Case Officer: Andrew Thompson

Recommendation: Approval

Proposal: Partial Discharge of Condition 12 (details of the provision of a bus stop with shelter) of 18/00803/OUT

TITLE: **Plan 1
Site Location and Existing Layout**

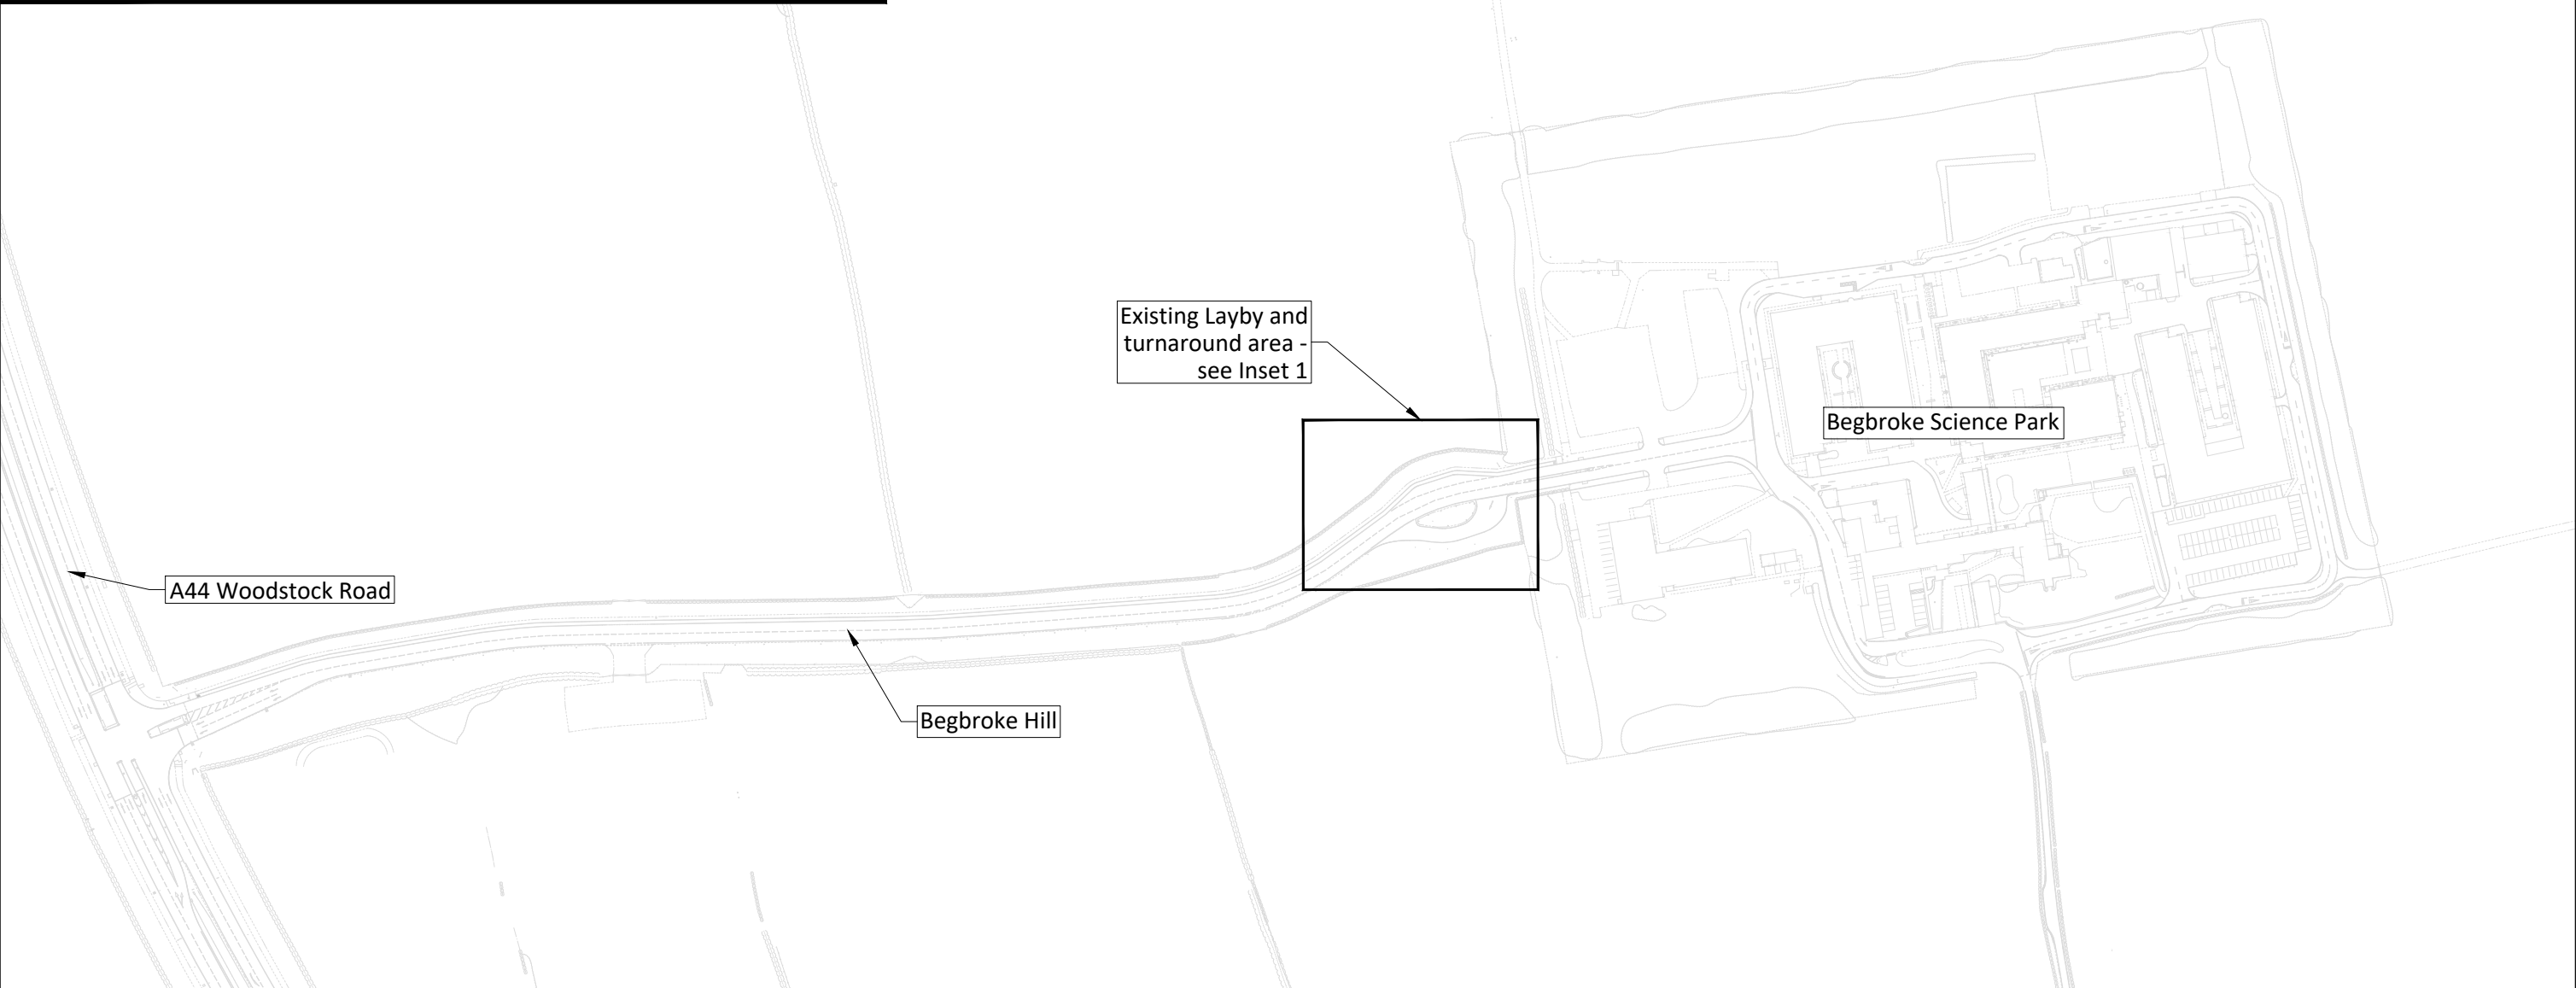
- 2.2. The location and existing layout of the bus turnaround area is shown on the submitted plans as being on the northern side of Begbroke Hill at the entrance to the main science park. In this location there is an existing layby on the northern side of Begbroke Hill, and a turn-around loop on the southern side.
- 2.3. The layby is 3.5m deep, with 15m tapers at either end. The turn-around loop on the southern side of Begbroke Hill has a jug-handle profile, with a width varying between around 5m to 12m.
- 2.4. A 3m wide footway cycle way runs along the northern side of the layby. This footway cycleway is marked as a segregated facility (1.5m footway/1.5m cycleway) and provides access from the A44 Woodstock Road into the Begbroke Science Park, a distance of around 560m.

TITLE: **Plan 2
Proposed Bus Shelter - Swept Path Analysis**

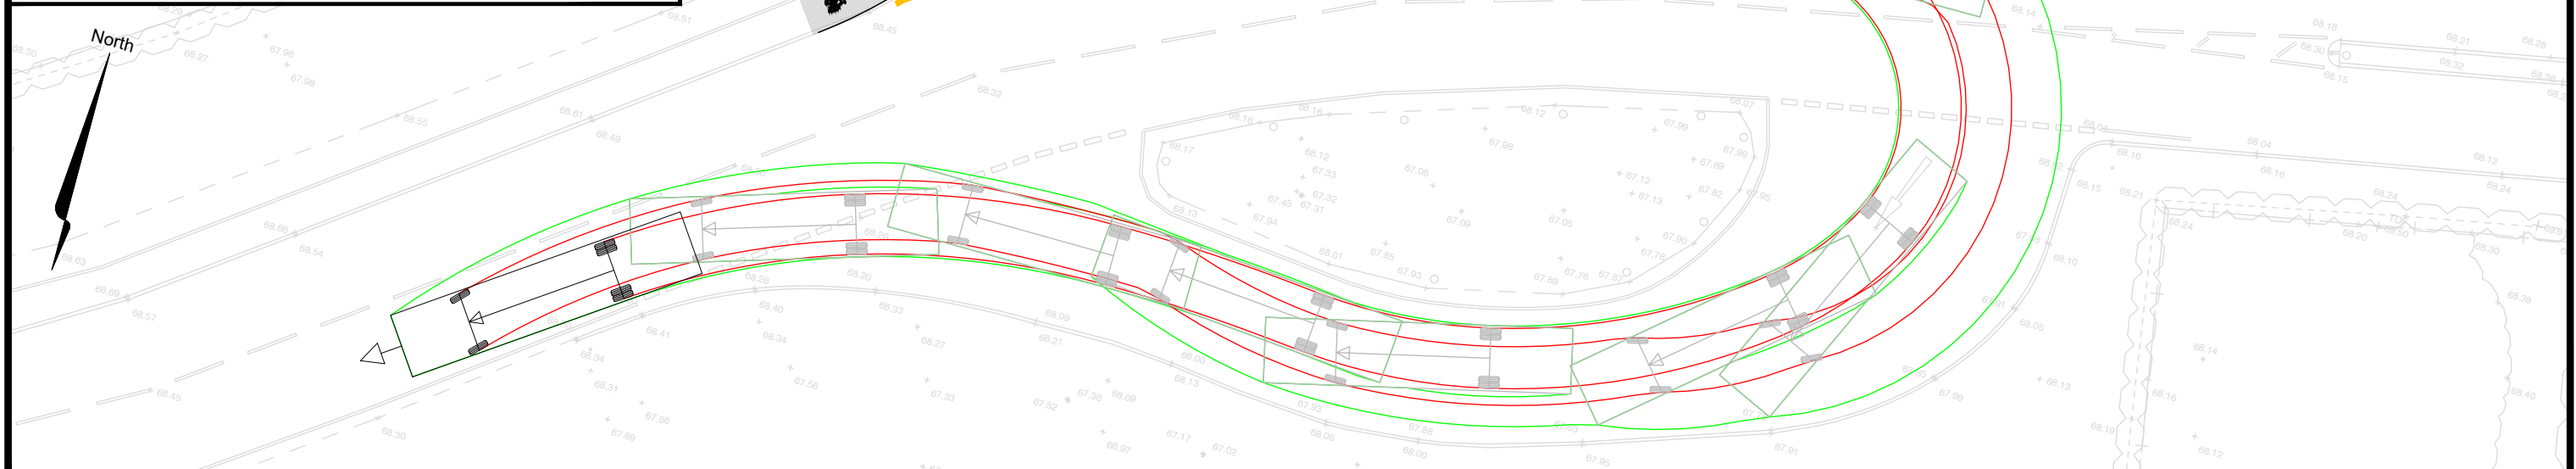
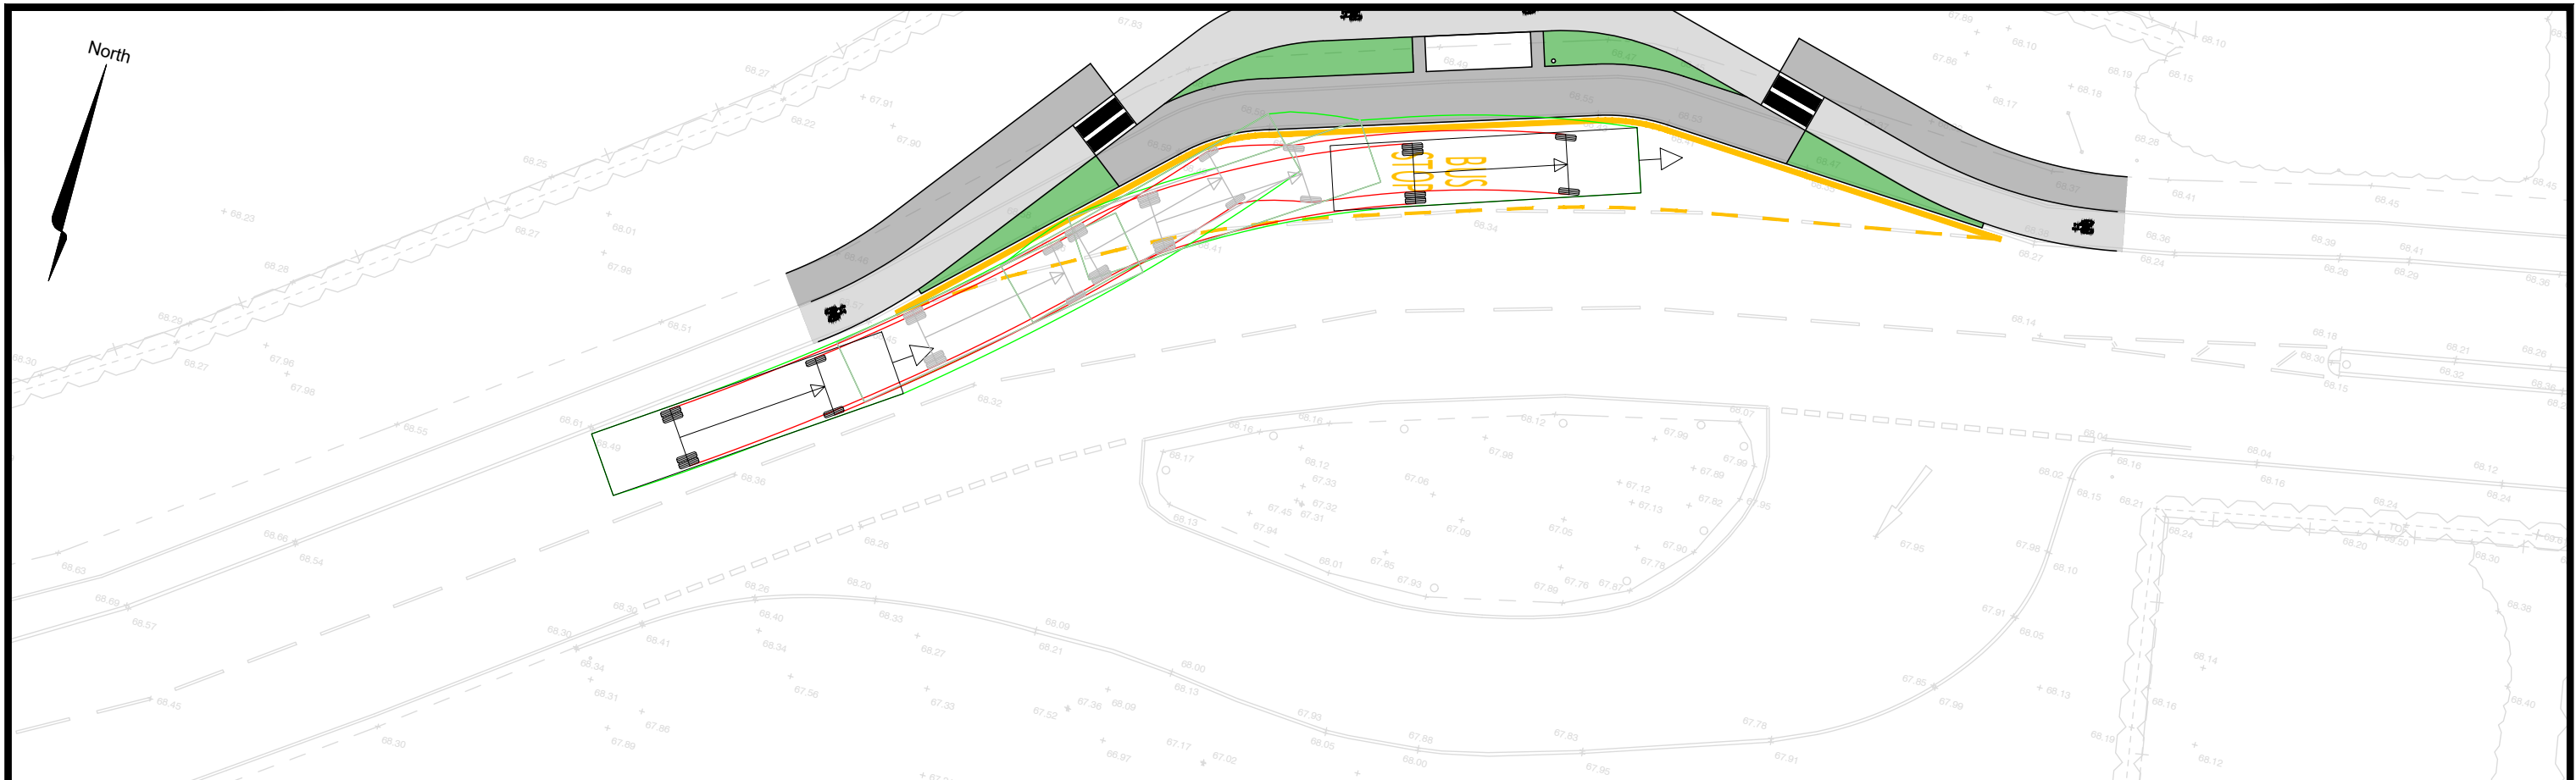
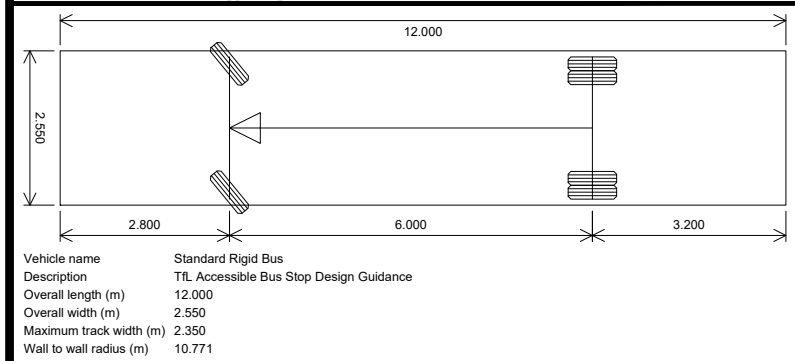
- 5.1 As required by the condition the proposed location of the bus layby is located within existing infrastructure and allows for turn and manoeuvre and includes the provision of a bus stop including a shelter within the site at the existing turnaround area at the eastern end of Begbroke Hill
- 5.2 The applicant has entered into discussions with a service provider to either divert an existing public bus service into the site or provide a new public bus service to serve the site.
- 5.3 Therefore the above details are considered acceptable and would also not compromise the wider allocation delivery.
- 5.4 The detail is considered to be acceptable, the programme of implementation has not been submitted and therefore cannot be discharged at this time.

are considered to be acceptable and it is noted that discussions with Stagecoach are ongoing. In order to discharge the condition fully, the proposed bus stop and shelter shall be provided and the public bus service implemented in accordance with details and a programme to be first submitted to and approved in writing by the Local Planning Authority.
